From:
Sent: 04 March 2019 13:38
To: DCAdmin
Subject: Comments on planning application number 2019/90265

I am emailing to express my concerns and objections on planning application number 2019/90265, 21 Bank Lane, Upper Denby, Huddersfield, HD8 8US, the Erection of Office/ Studio.

Mock Up Of Garden Area With Office/Studio

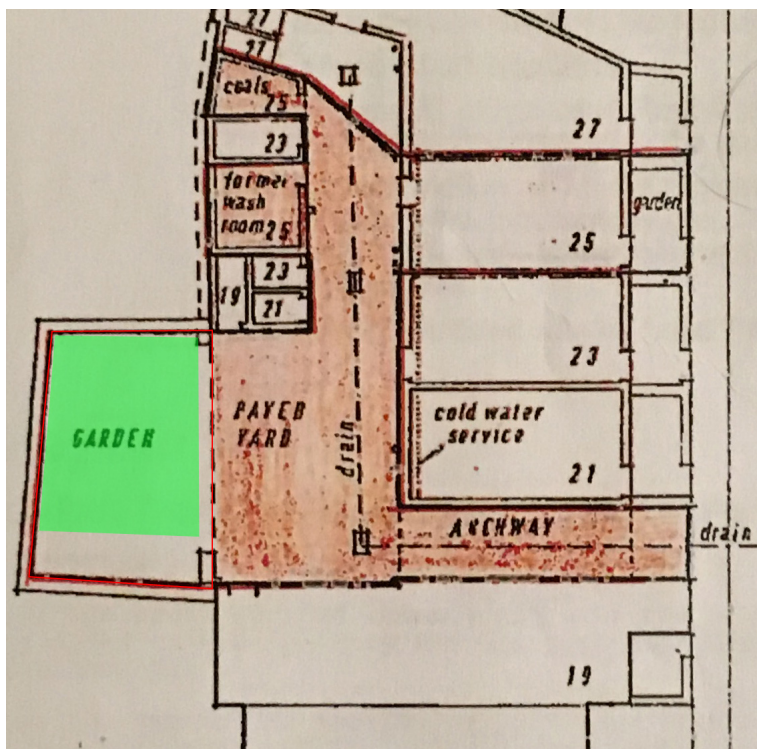
I do not think it is appropriate to build such a large and tall building in the middle of a row of low walled gardens as it would look out of place with the current uniformed, scenic view of the area. There are a large number of visitors that come to this village to enjoy the quiet rural picturesque scenery and animals and this building would spoil the scenic views visitors enjoy..

and raised patio area is next of the proposed office/studio build. The raised patio is about a metre higher than (one drawing shows overall highest of the building of 40 metres?) Please can I have confirmation of the current height of the office/studio building. Also if it is incorrect can the neighbouring households to this planning proposal also be informed.
